SLOUGH MULTIFUEL EXTENSION PROJECT

Planning Inspectorate Ref: EN010129

**Document Ref: 9.2 – Applicant’s Responses to the Examining
Authority’s First Written Questions (ExQ1)**

Applicant: SSE Slough Multifuel Limited

Slough Multifuel Process Diagram

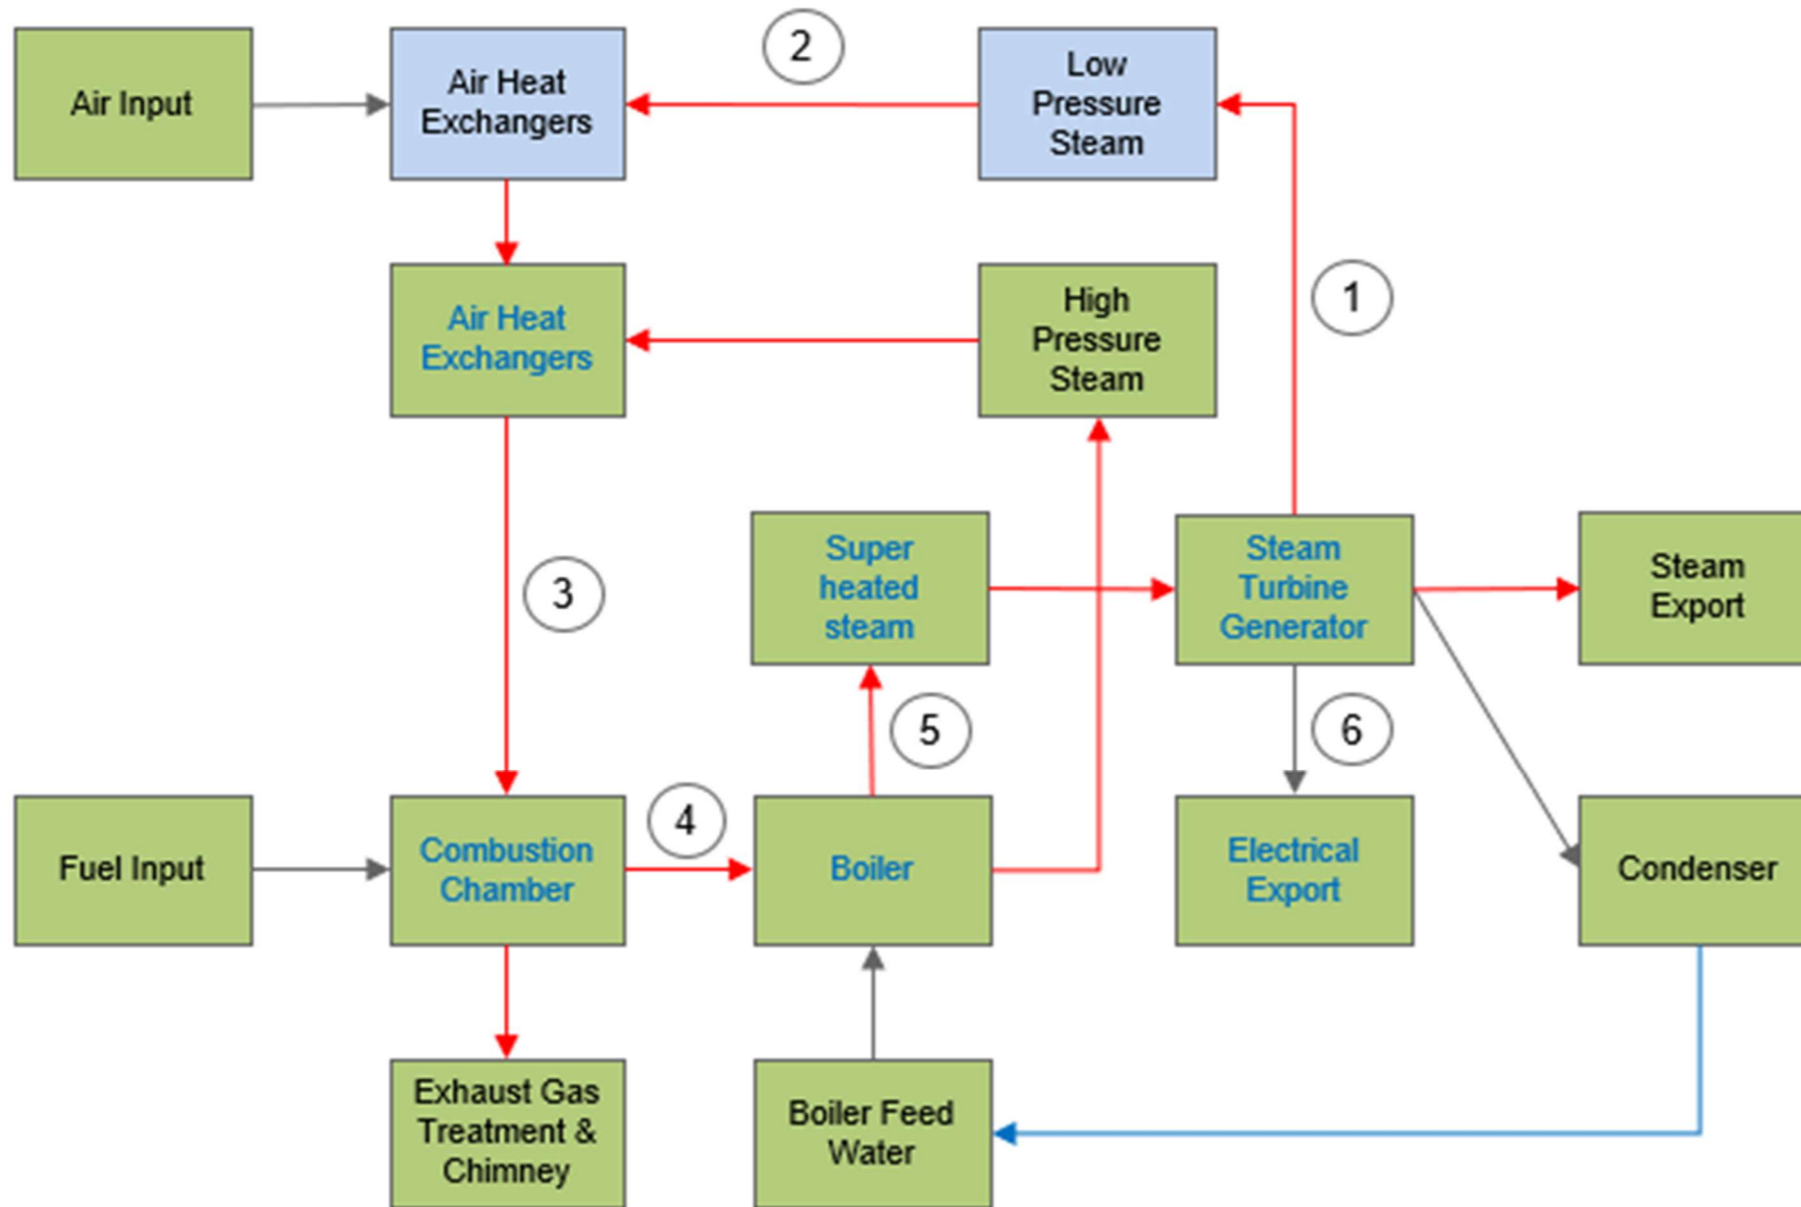
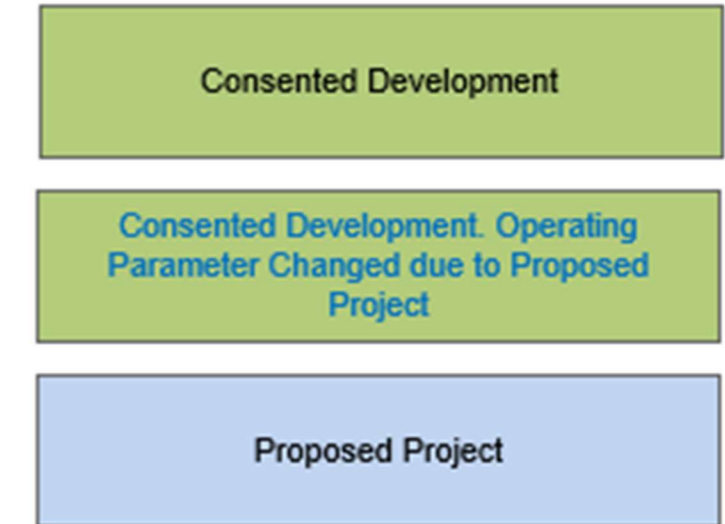
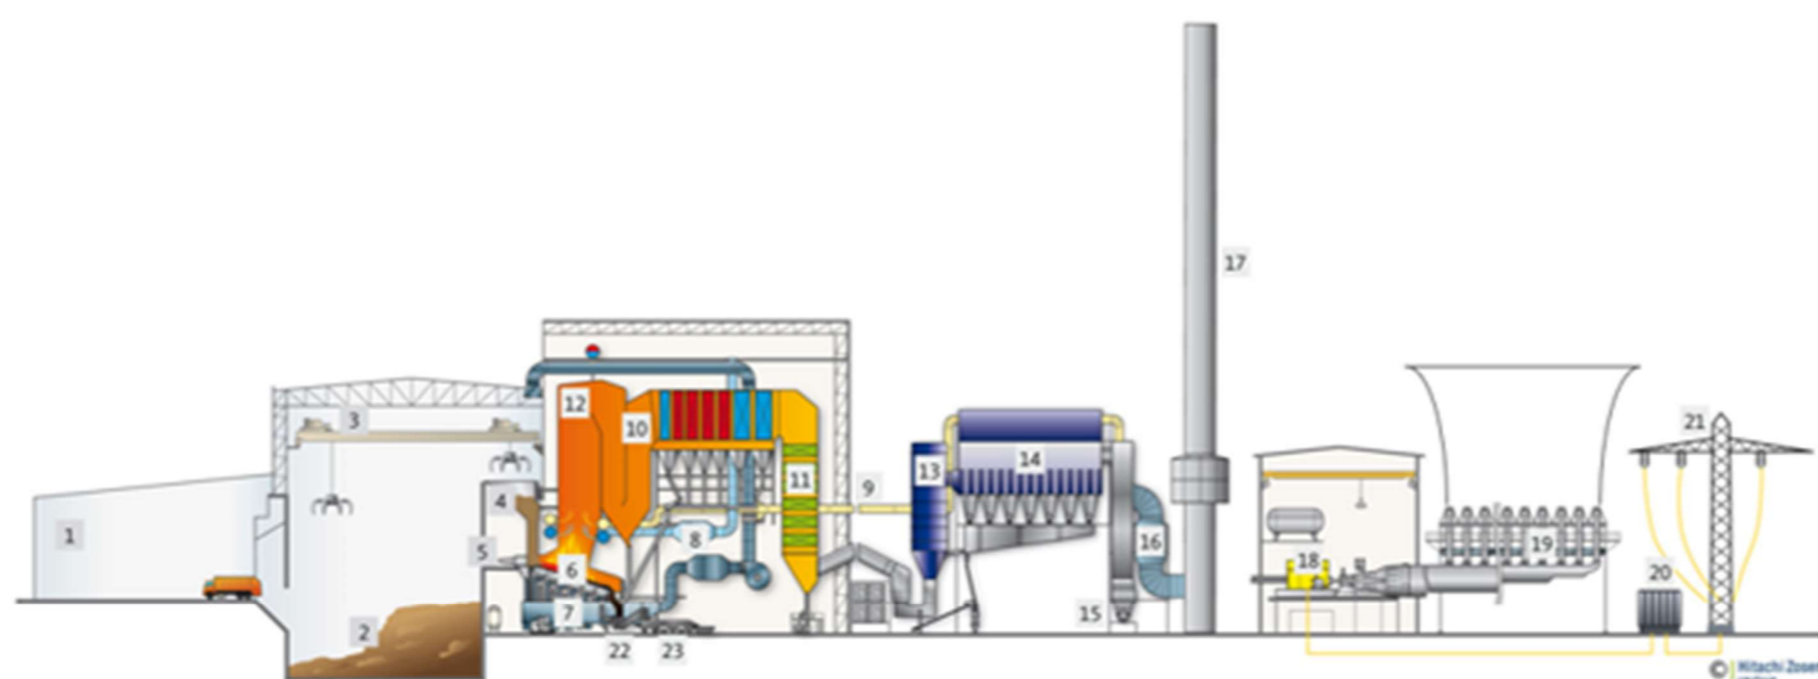
Air Quality and Emissions			
Q1.3.1	Applicant	Paragraphs 2.5.1 to 2.5.3 of ES Chapter 2: The Proposed Project [APP-027] and paragraph 8.1.5 of ES Chapter 8: Air Quality [APP-033], outline how the Proposed Development seeks to increase the generating capacity of the consented scheme. Please clarify the point at which (within the Energy from Waste process) the efficiencies and increased gross electricity generation capacity would be delivered by ‘interventions’ as part of the Proposed Development. For the ExA to better understand these points, the Applicant is requested to provide a process flow(s)/schematic block diagram(s) showing the Energy from Waste process which clearly identifies these interventions. In responding please have particular regard to the combustion element in demonstrating the assertions that “The Proposed Project does not introduce any new emissions nor change the exhaust gas parameters” (paragraph 8.8.16 of [APP-033]) and that the pre-heating of combustion air would be achieved without the use of additional fuel [APP-027, paragraph 2.5.1].	Further to the answer supplied in Q1.2.4 part b, the Consented Development includes 2 boilers with a total thermal capacity of 183MWt. The Proposed Project makes no changes to the boilers supplied for the consented development, their fuel consumption, or emissions. The intervention from the Proposed Project occurs where low pressure steam is extracted from the steam turbine and fed to air heat exchangers. The steam fed to the air heat exchangers increases the temperature of the combustion air being fed into the boilers which allows more steam to be produced for the same amount of fuel. The Proposed Project recovers energy which would otherwise have been wasted in the process. Please refer to the Slough Multifuel Process Diagram and Slough Multifuel Process Overview contained in Appendix 1 of this document.

The air systems are identified by #7 and #8 on the illustration. Combustion air is taken from the waste bunker so that it is under negative pressure (i.e. the odour does not flow out, clean air is drawn in) and the odorous air is used to feed the combustion chamber. The new air heat exchangers would be provided in the air systems to raise the air temperature before it enters the combustion chamber. The turbine is identified by #18 on the illustration. A steam extract would be provided to supply heat to the air heat exchangers.
